The Planning Department  
Ribble Valley  
Chitheroe

Planning application Number. 3/2023/0324  
Newlands Back Lane. Chipping.

project	project number	drawing number
Newlands House	2306	PL.01
Proposed Site Plan, Floor plans and Elevations		
scale	date	status
1 to 100 @ A1	april 2023	planning
revision	revision	
A	A

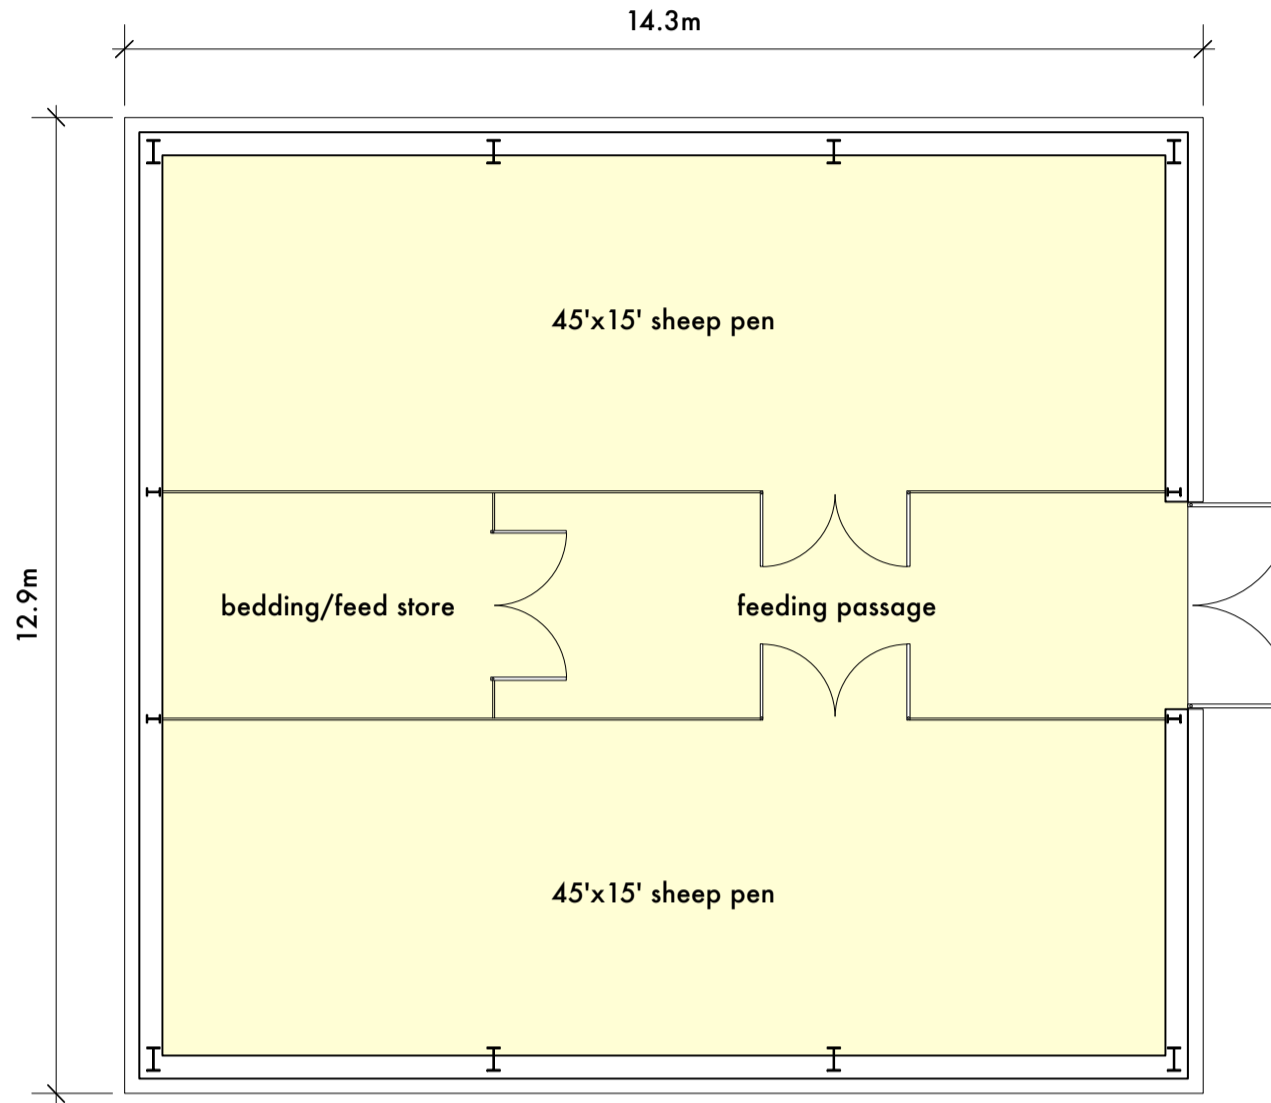
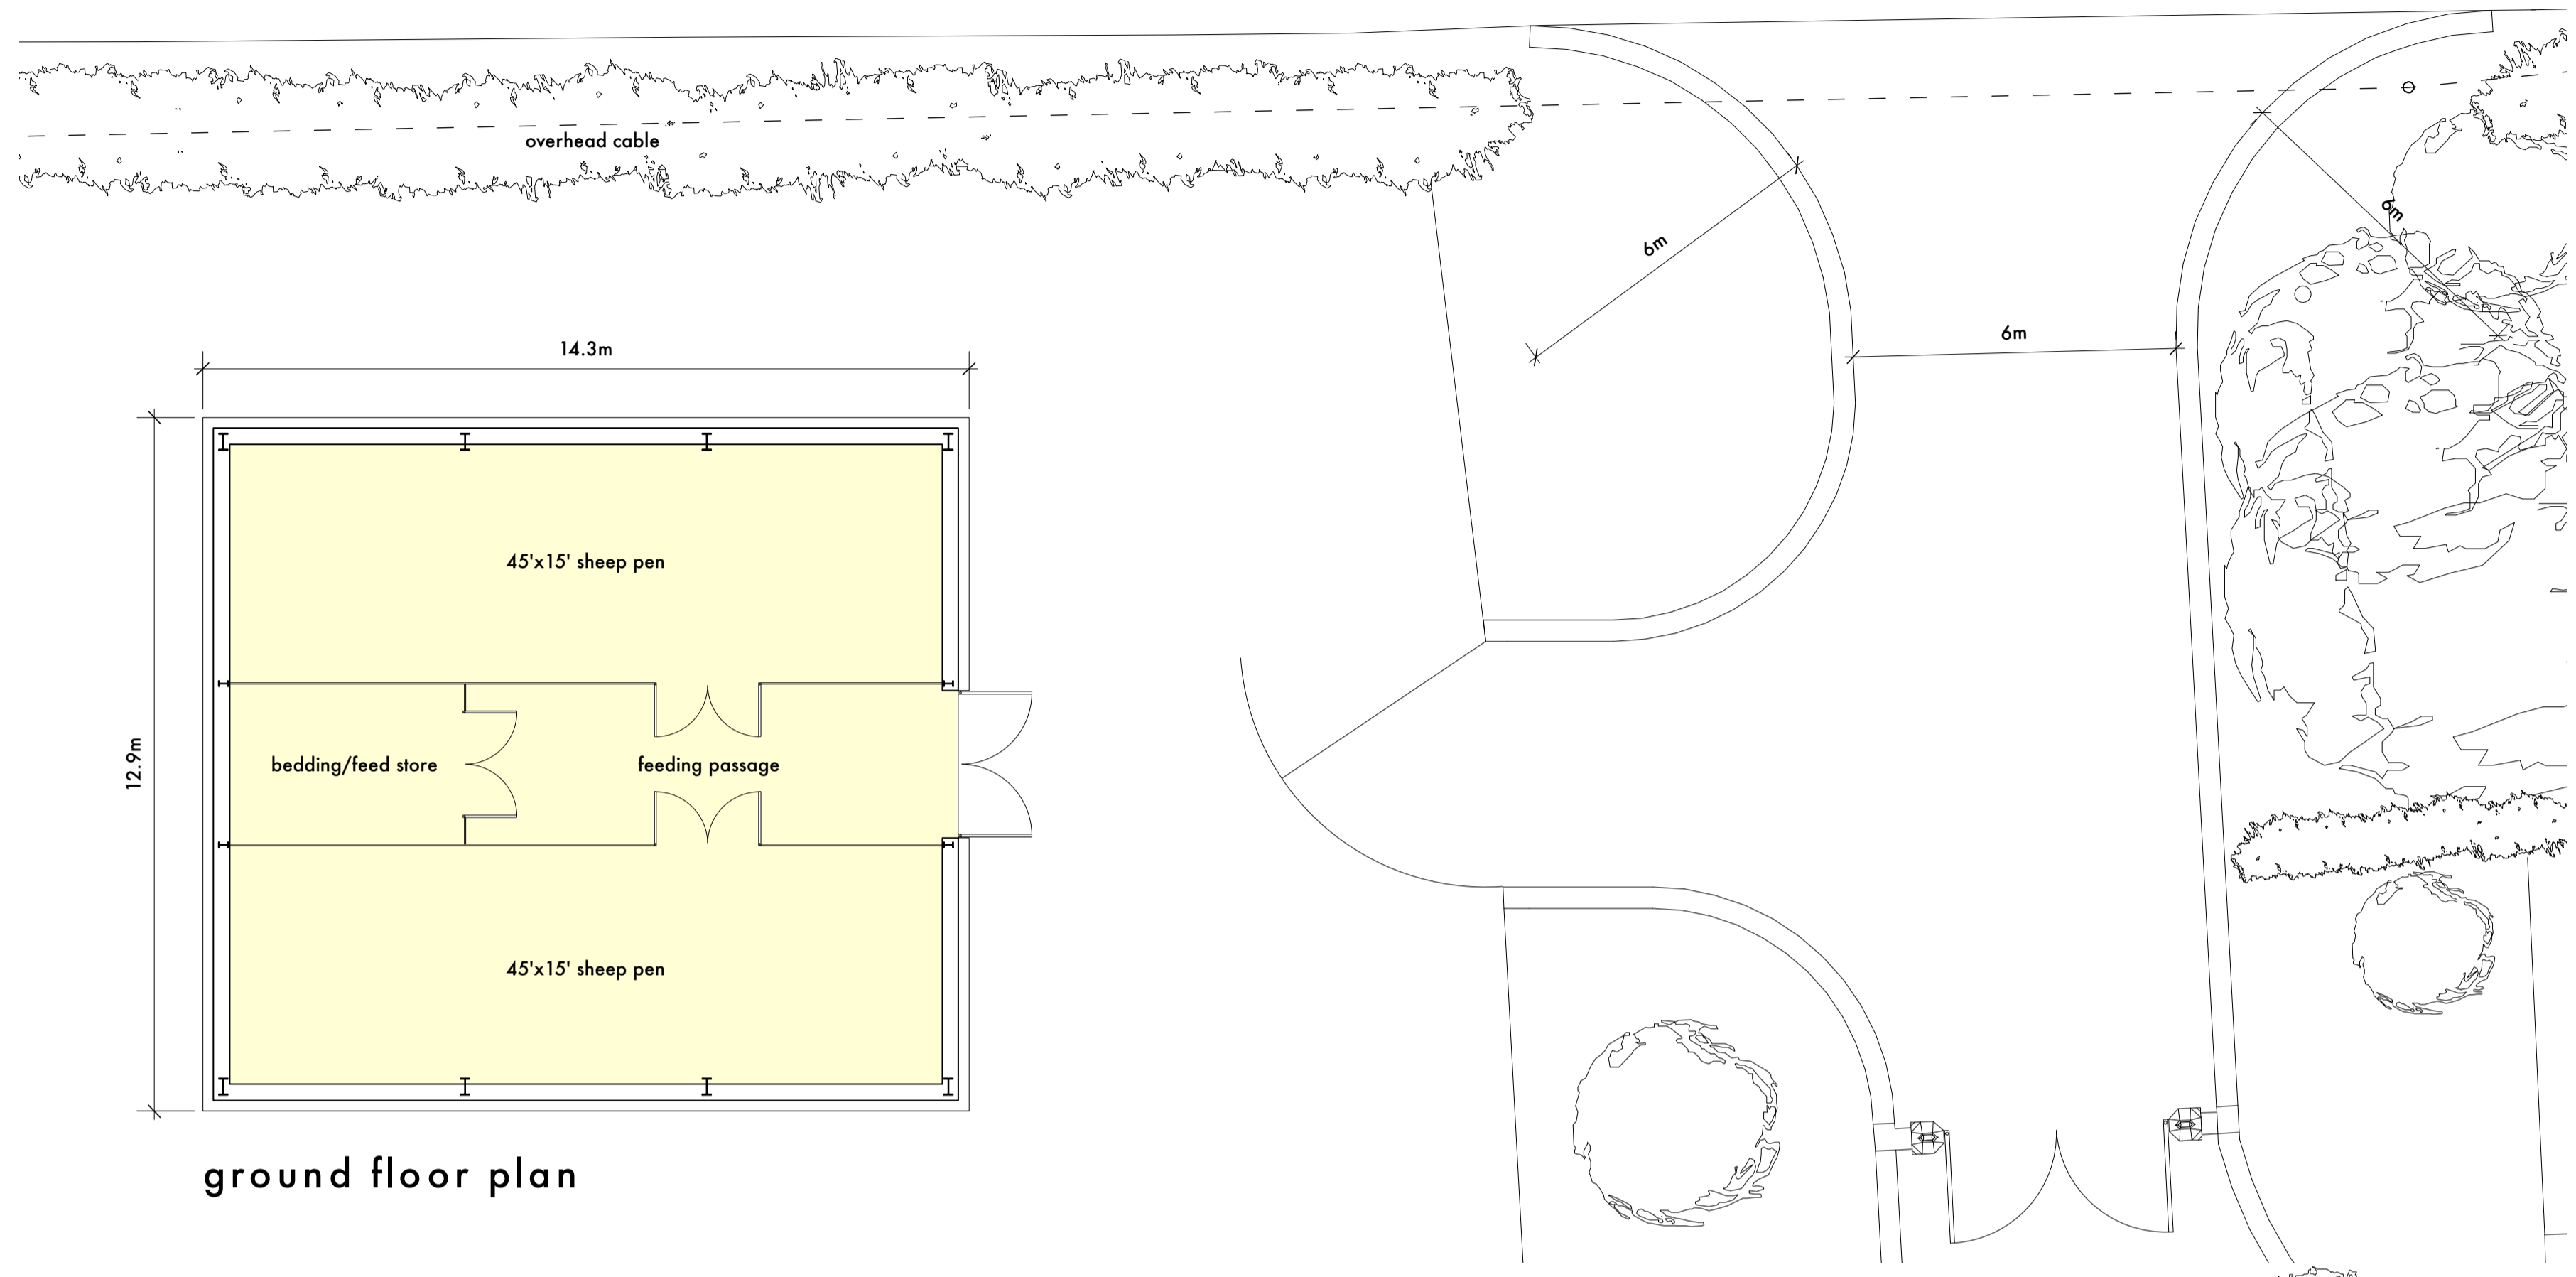
The applicant states that he wishes to have 50 Breeding Ewes on his land which from my observations is poor wet land and not good quality meadow. In my humble opinion, after [REDACTED] these numbers are overstated. The land would struggle to maintain 15-20 ewes as it would also need to support the lambs from the ewes. Therefore the size of the building is excessive.

Why is the building so near to the road, in front of the building line of the house? The siting of the building is not ideal from a farming point of view with restricted access to the agricultural land. Access is on to the busy main road from Longridge to Chipping very near to a severe bend, perhaps access to the field could be from down the side road, Sandy Bank, more ideal for service vehicles loading etc and the agricultural building would be on the agricultural land.
